In reply please quote: 11/02831

7 July 2016

**SSD 7564 - PROPOSED WAREHOUSE/DISTRIBUTION AND INDUSTRIAL FACILITY -
THE HORSLEY DRIVE AND COWPASTURE ROAD, WETHERILL PARK**

02 B-DOUBLE TURNING DIAGRAM 02
1:500 @ B1

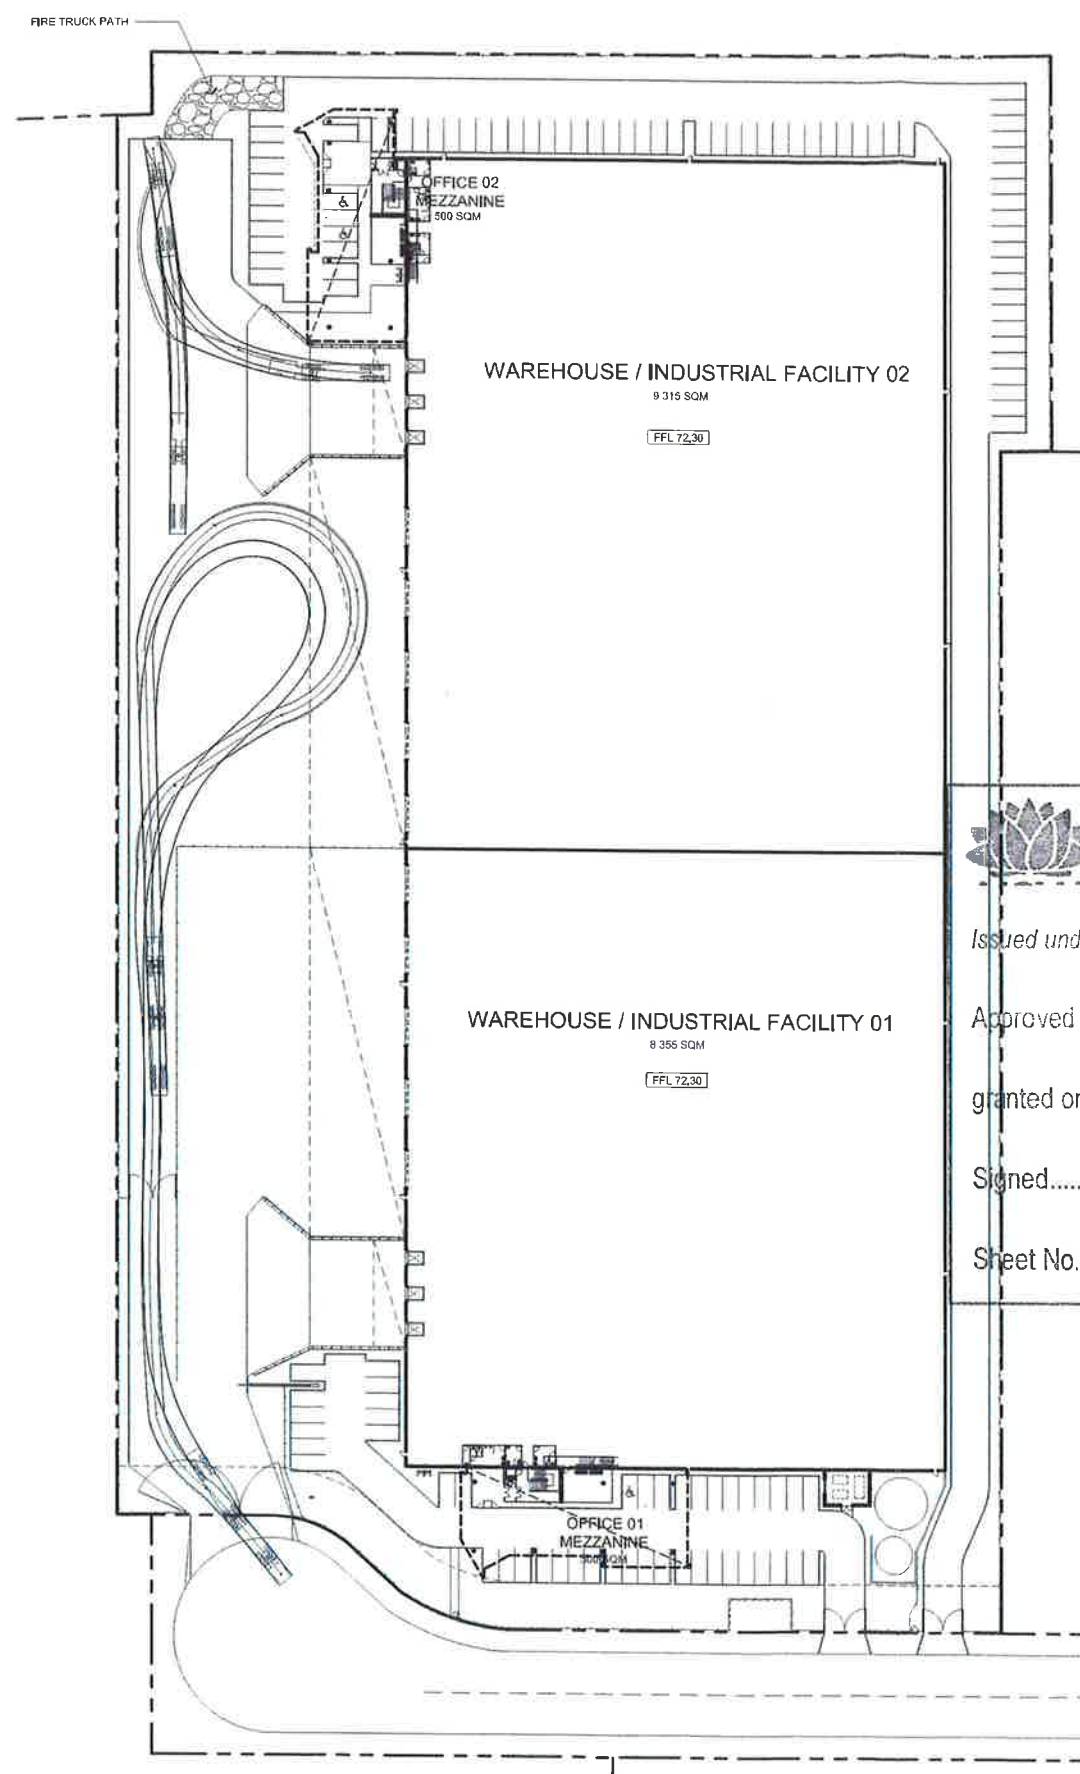
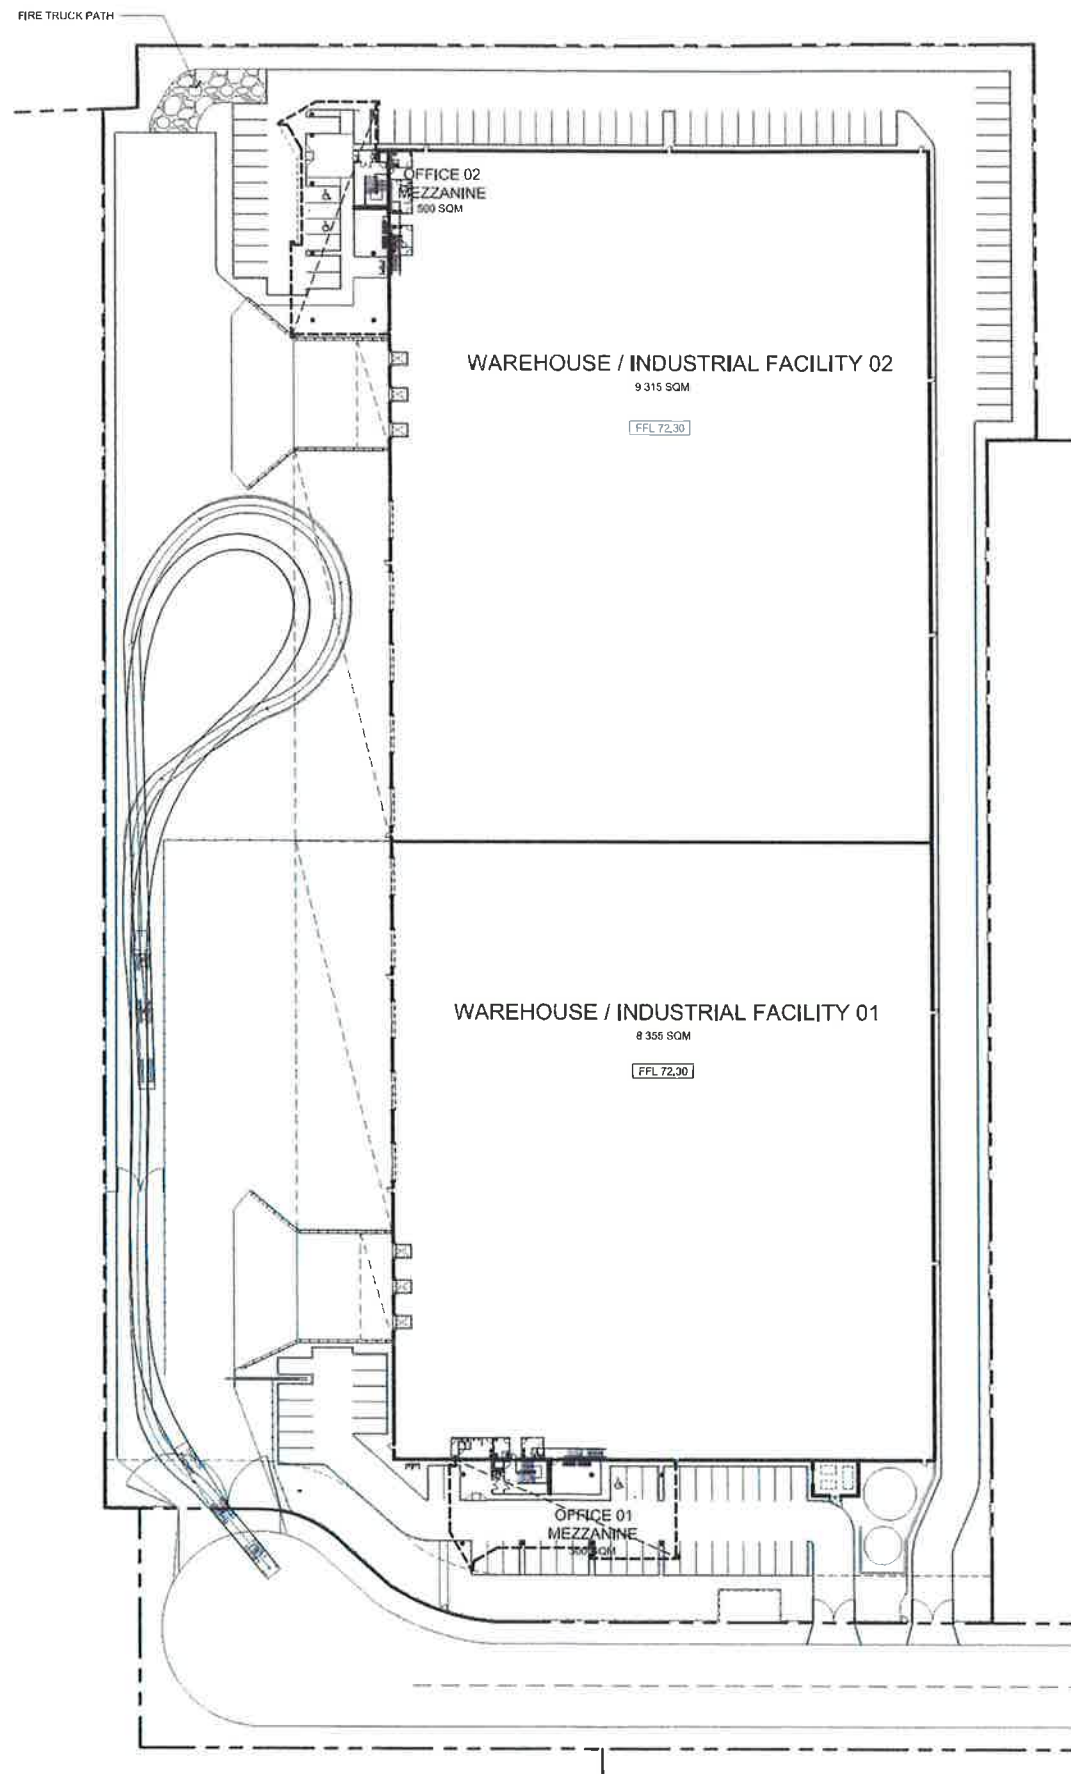
1. The Construction Traffic Management Plan shall detail construction vehicle routes, number of trucks and hours of operation.
2. Loading Dock Management shall address the conflict between entering and exiting B-Double vehicles.

EROSION AND SEDIMENT CONTROL PLAN
SCALE 1500

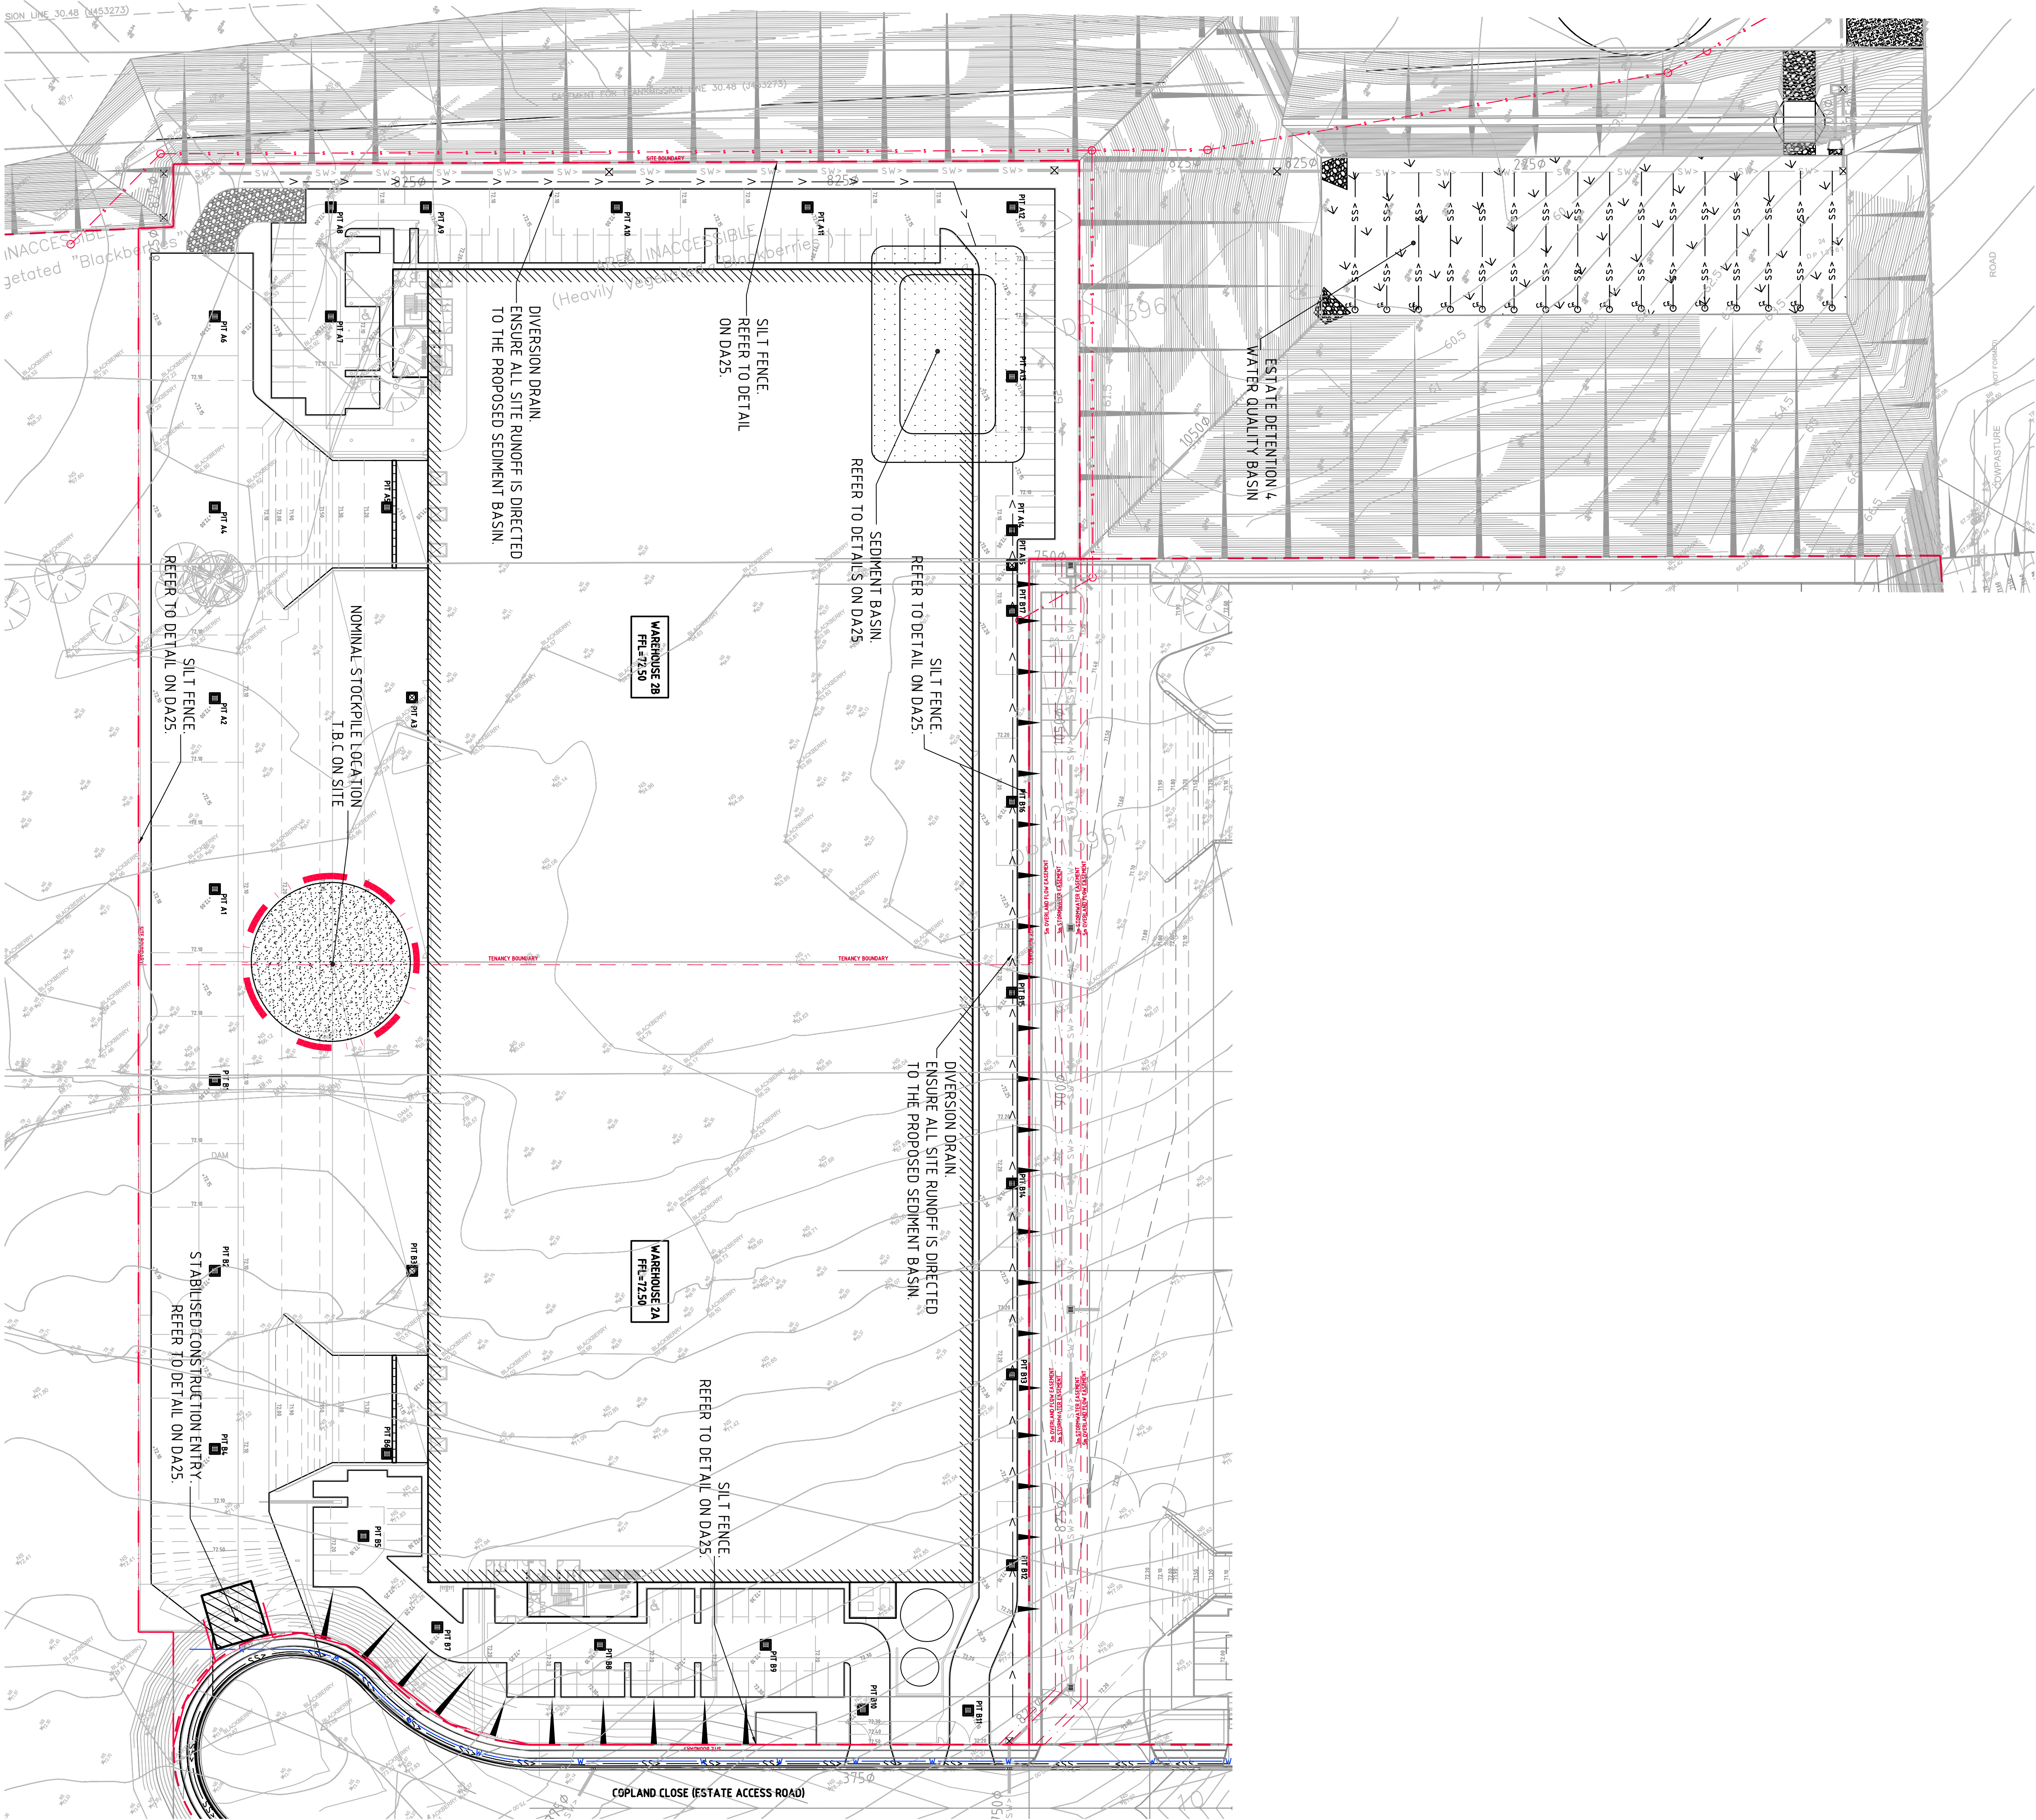
The ESCP shows details of a sediment basin. Operational notes include details of the assessment of water for sediment concentration and treatment for flocculation of sediments prior to discharge to stormwater. No mention of any required pH adjustment is made.

- A street sweeper will be onsite at all times for dust control;
- Site plans show the location of environmental controls and stockpiles;
- Trucks will be cleaned of excess mud prior to exiting the site via a 'shaker grid'. No further details are given of this operation. A stabilised access is shown on the site plan without a shaker grid, and no cleaning area is shown;

- Refuelling is to be carried out in a designated 'bounded' (sic) area. This is not shown on site plans;
- Concrete washout areas are not shown on the site plans;

- Site plans showing the location of all environmental controls, including shaker pads, refuelling areas, and washout areas;
- Details of any required pH adjustment of sediment basin water prior to discharge.
